## DELEGATED DECISION

Planning permission (part retrospective) has been sought for the erection of new two storey 4 bed dwelling with basement; new garage; cycle and bin storage and associated amenity space following demolition of the existing dwelling.

20342/APP/2022/3634      5A HARROW VIEW HILLINGDON

PROPOSED
GARAGE PLAN

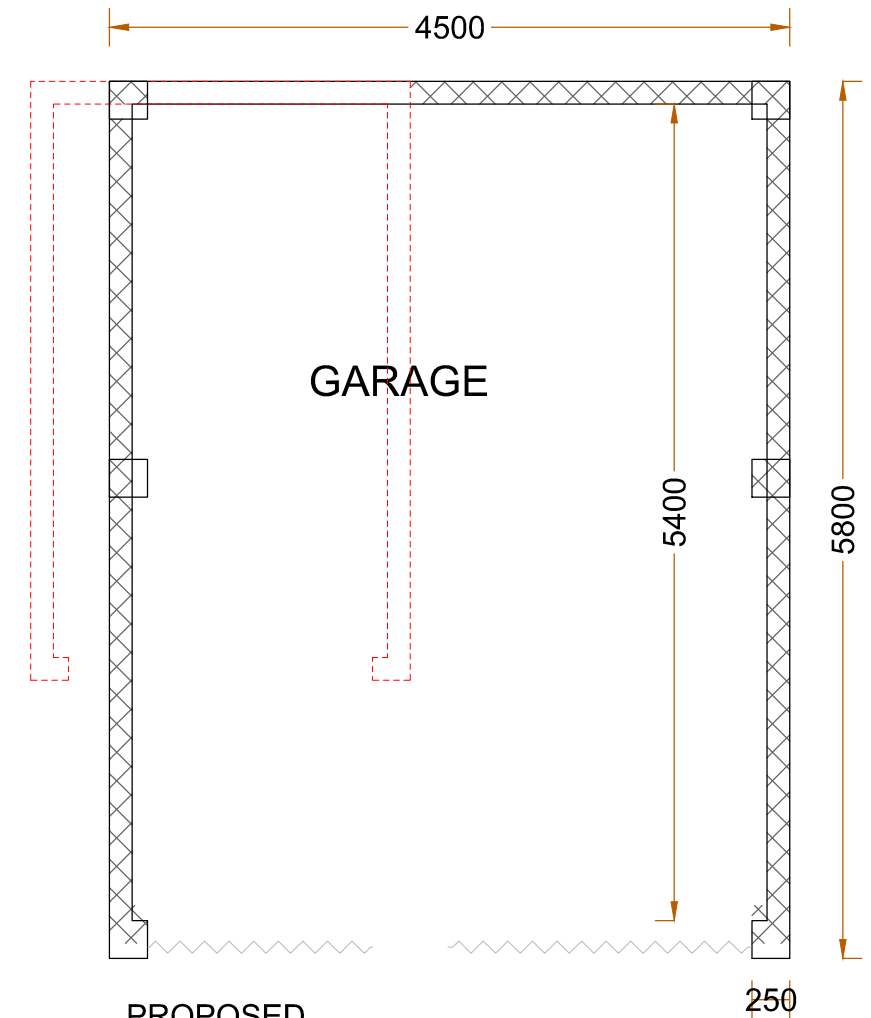
The London Plan Table 10.2 - Minimum Cycle Parking Standards requires that a minimum of 2 cycle parking spaces should be provided. Drawing 2022156.PA109 titled Proposed Garage shows

the proposed garage which has internal dimensions of 5.4m x 4.3m which would be large enough to accommodate 1no. car and 2no. cycles which will be acceptable.

SITE BLOCK PLAN

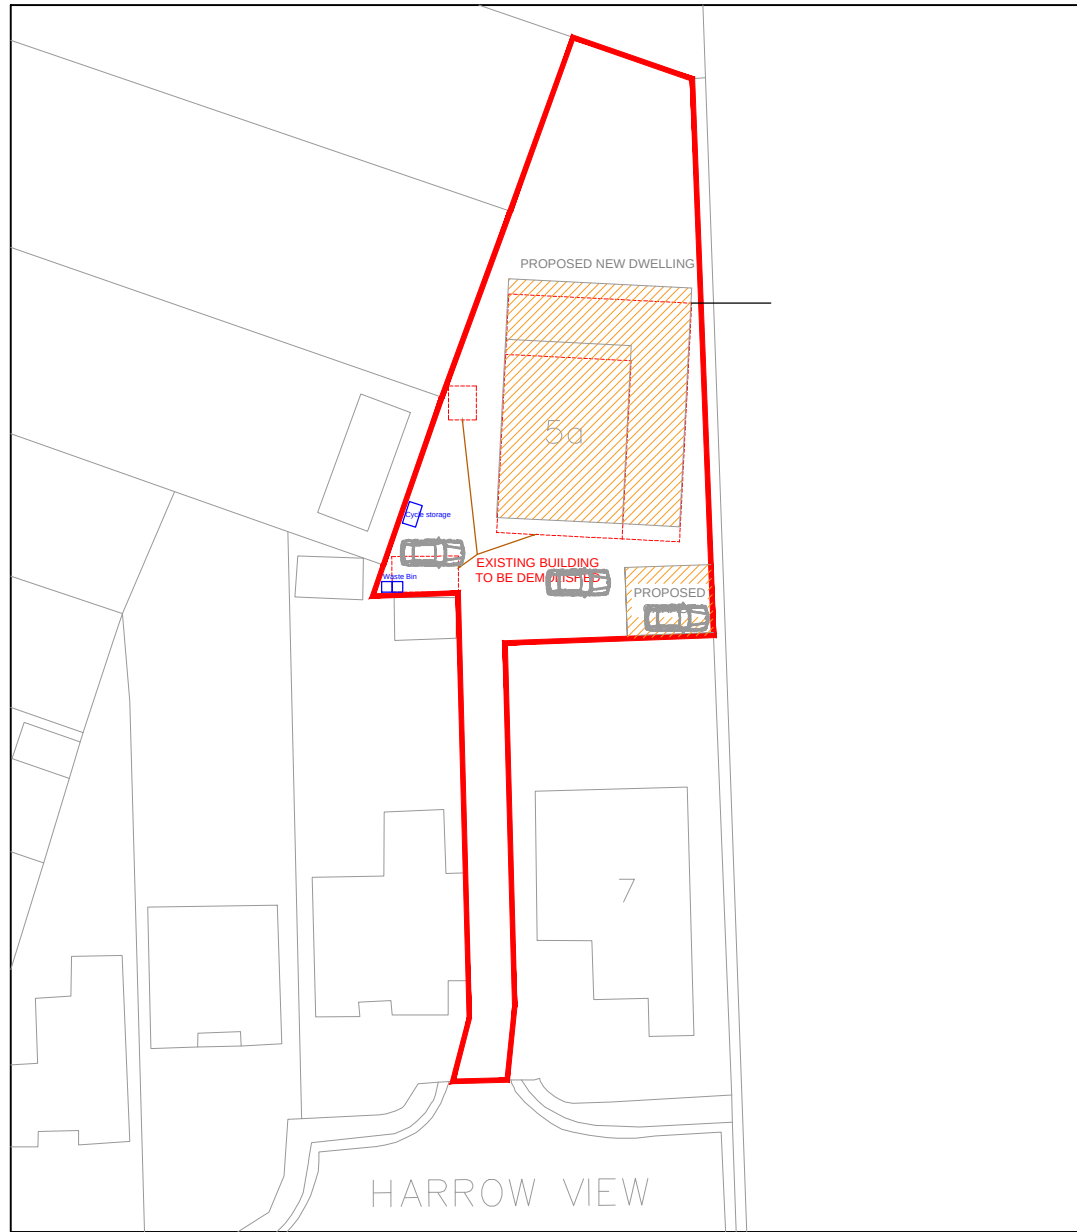
The published London Plan (2021) Table 10.3 - Maximum Residential Parking Standards allows all dwellings in Outer London PTAL 1-2 to have a maximum 1.5no. spaces. Drawing 2022156.PA107 titled OS Map, Location Map also includes the drawing titled Site Block Plan which shows a garage with parking for 1no. vehicle and 2no. additional car parking spaces which exceeds the maximum standard. 1no. parking space should be removed. The Site Block Plan should be amended and submitted for approval.

The Highway Authority therefore offers an objection to this application on highway grounds but would be prepared to revise this decision subject to the applicant providing an amended drawing showing reduced car parking.
